LISTED BUILDING CONSENT REPORT**REF NO:** WA/63/09/L**LOCATION:** Little Box Cottage
The Green
Walberton**PROPOSAL:** Application for Listed Building Consent for alterations to existing annexe & construction of new glazed link to cottage and alterations to existing dwelling to include the addition of two airbricks and replacement joists.**SITE AND SURROUNDINGS**

PLANS AND SECTIONS
ALTERATIONS TO ANNEXE AND CONSTRUCTION OF
NEW GLAZED LINK TO MAIN BUILDING
LITTLE BOX COTTAGE, THE GREEN,
WALBERTON BN18 0AT

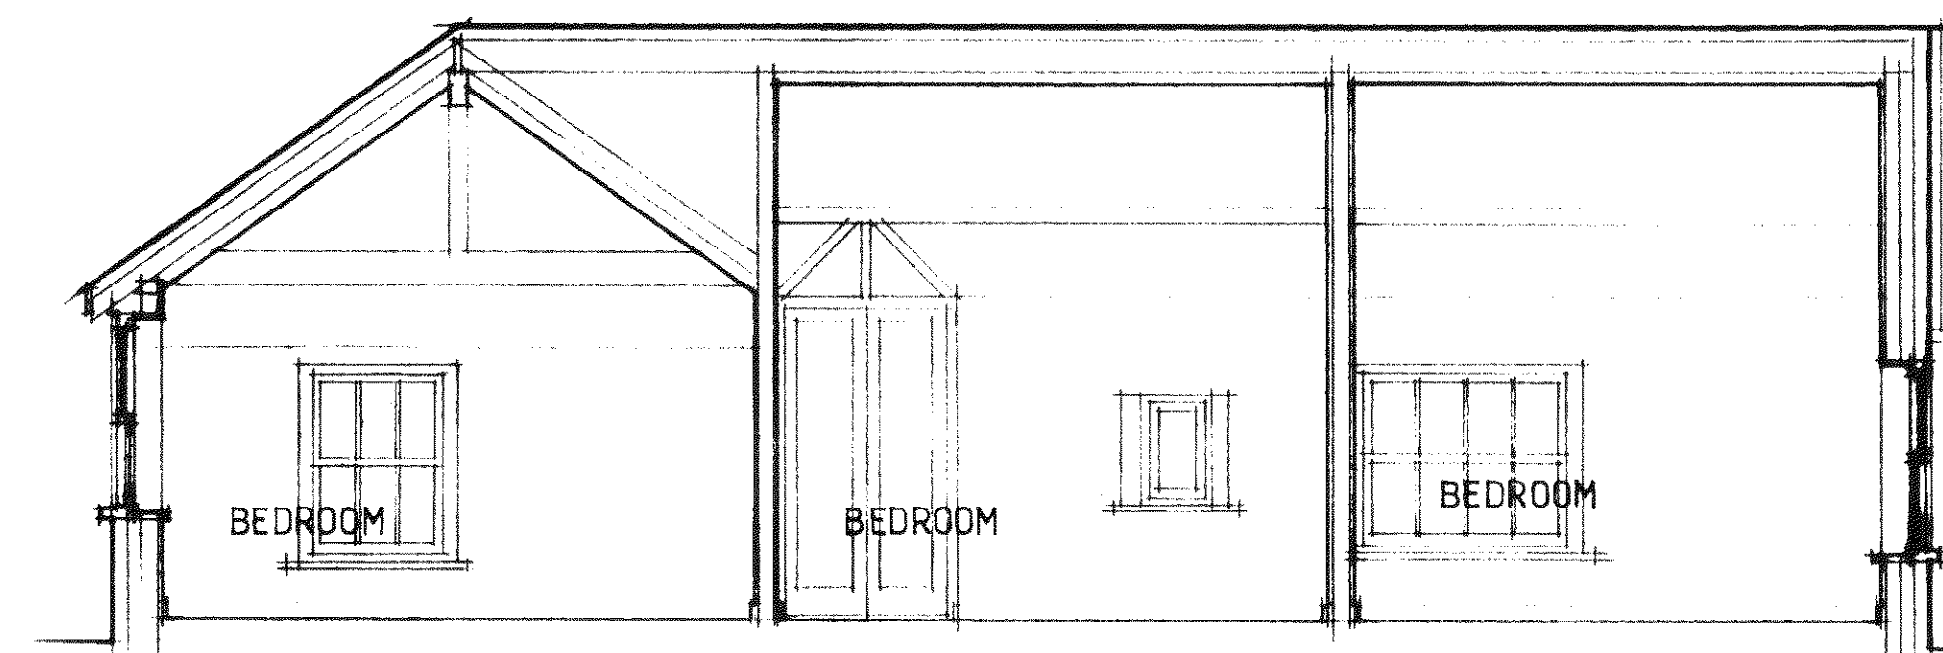
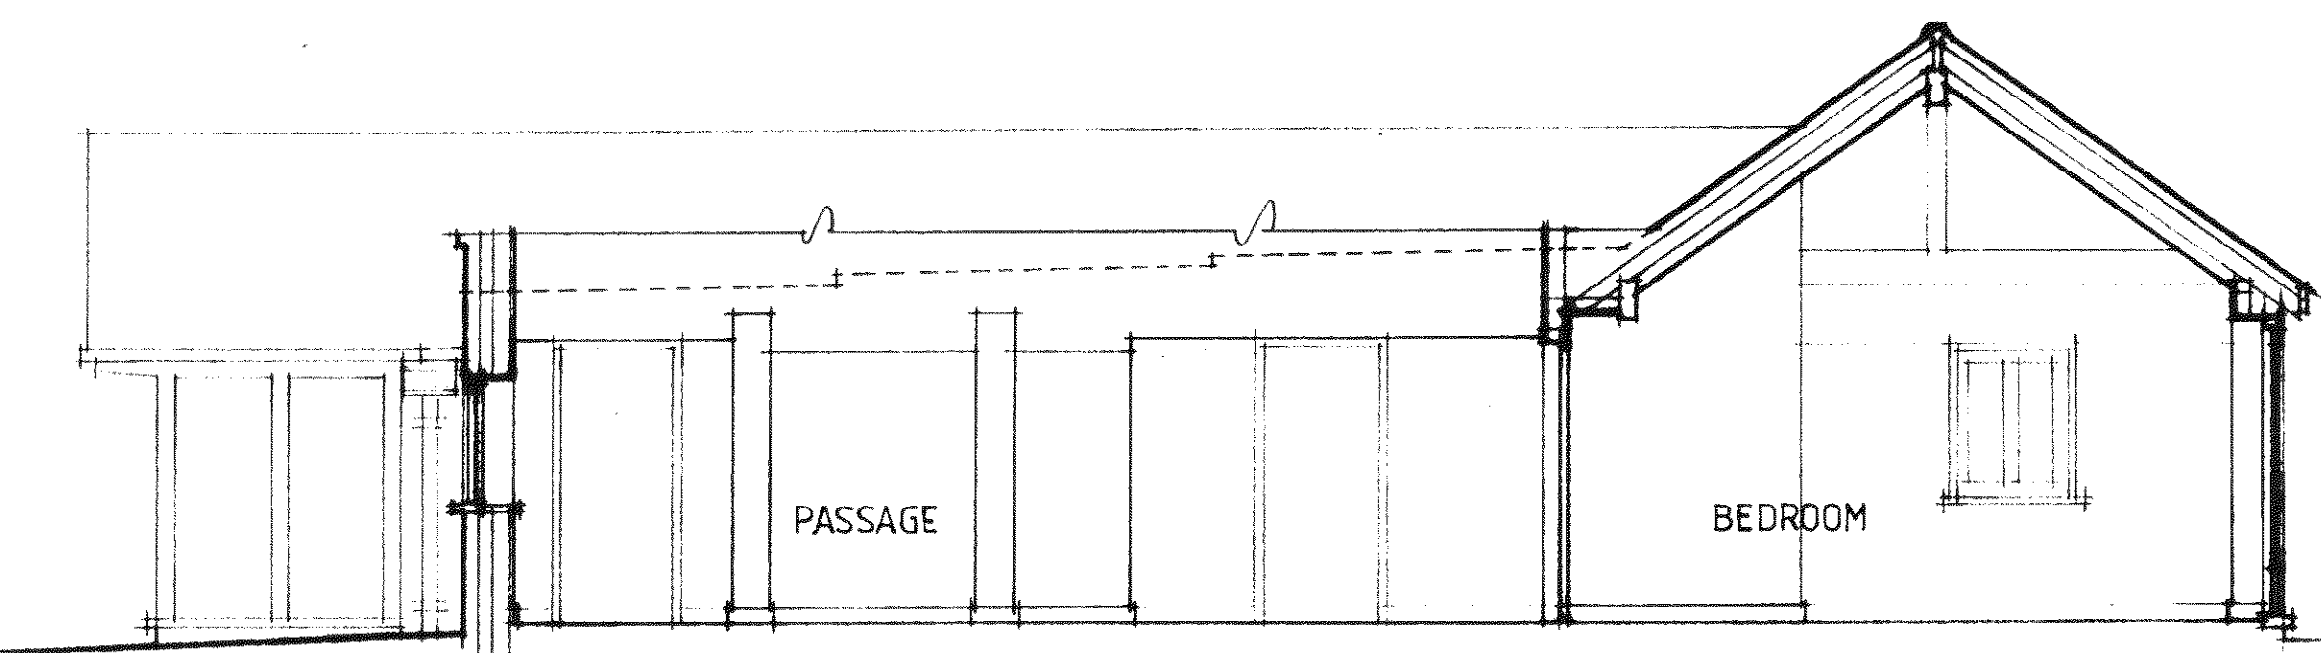
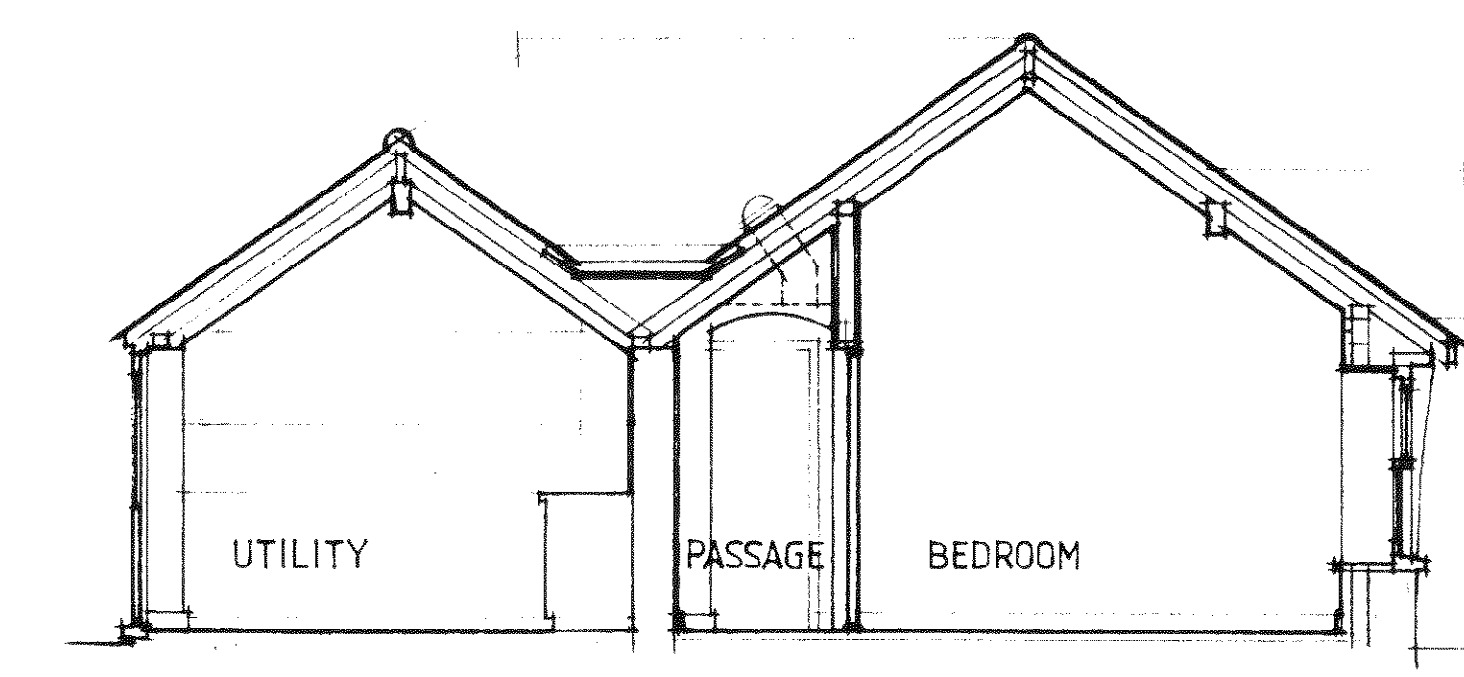
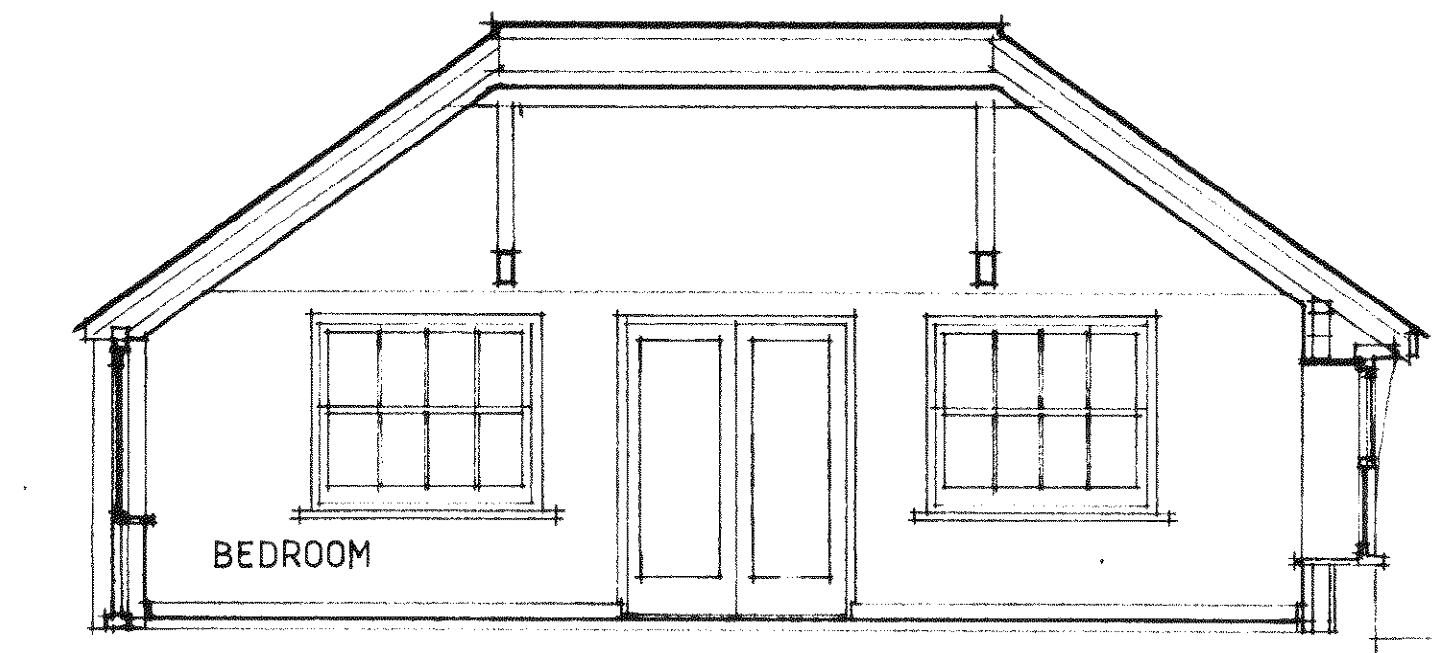
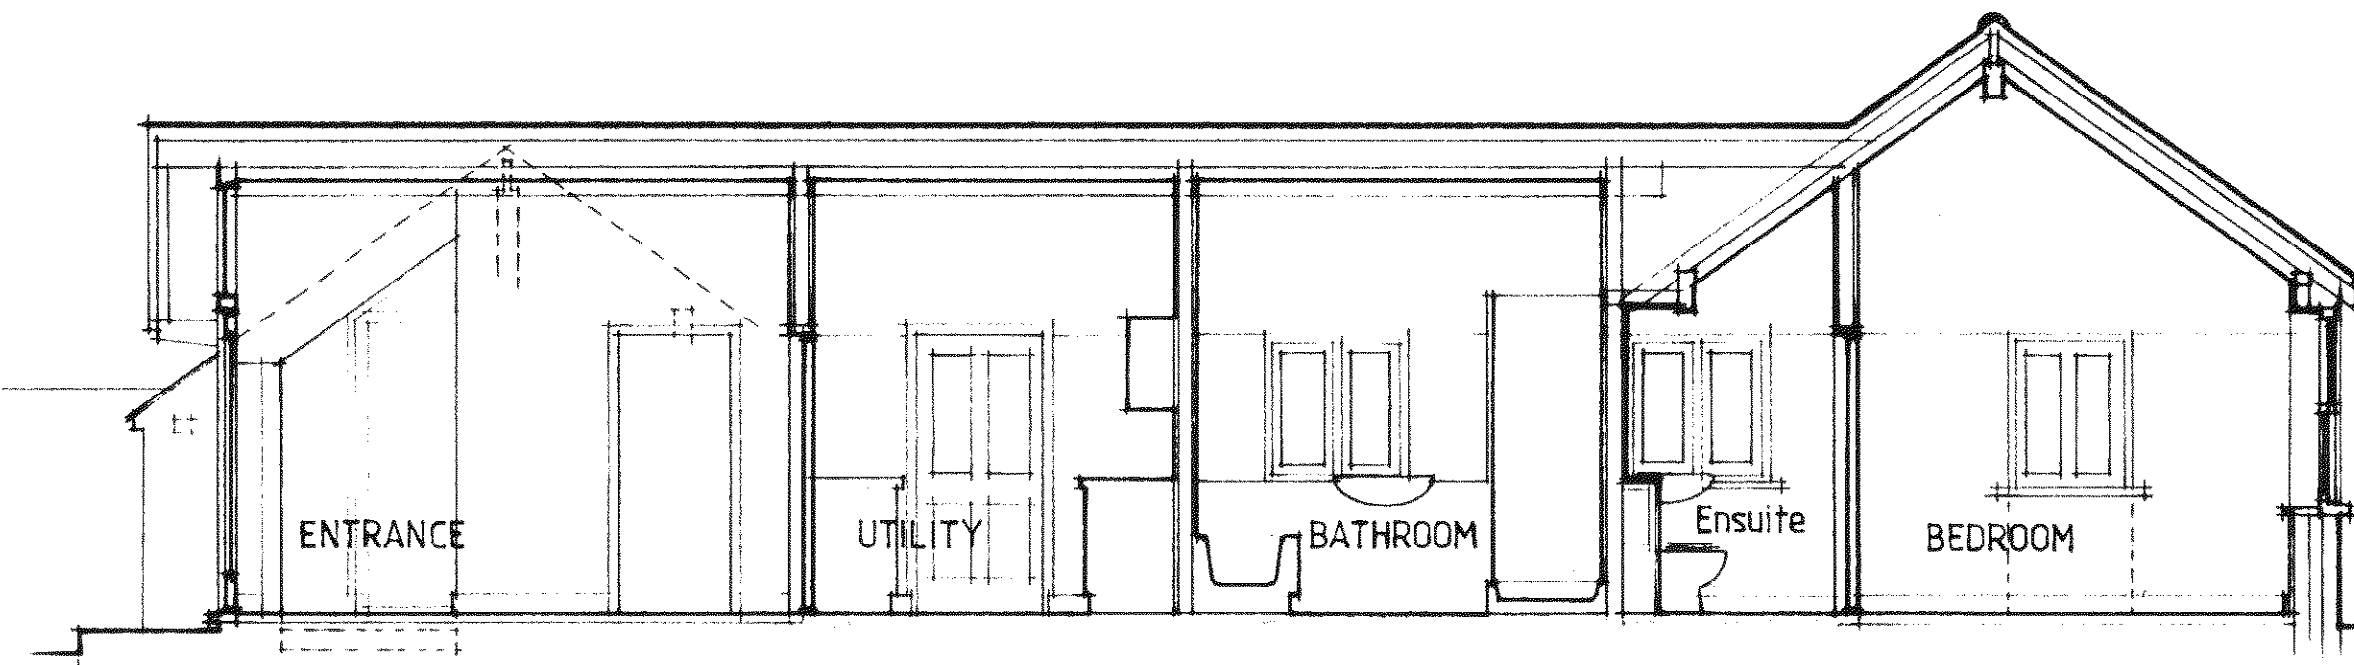
Comment: The quality of the drawings does not allow one to see exactly how the glazed link will adjoin the thatched roof of the cottage and we would request that this detail is carefully reviewed by the Listed Building Officer. Reason - so as not to detract from the character of the Listed Building.

Noted. Please see the response from the Listed Building Consultant below.

I make these comments further to our site visit. The glazed extension to the rear of the house to link the substantial rear building is acceptable. This is because the rear addition to the Listed house is 20th Century. The introduction of two ventilation bricks is acceptable.
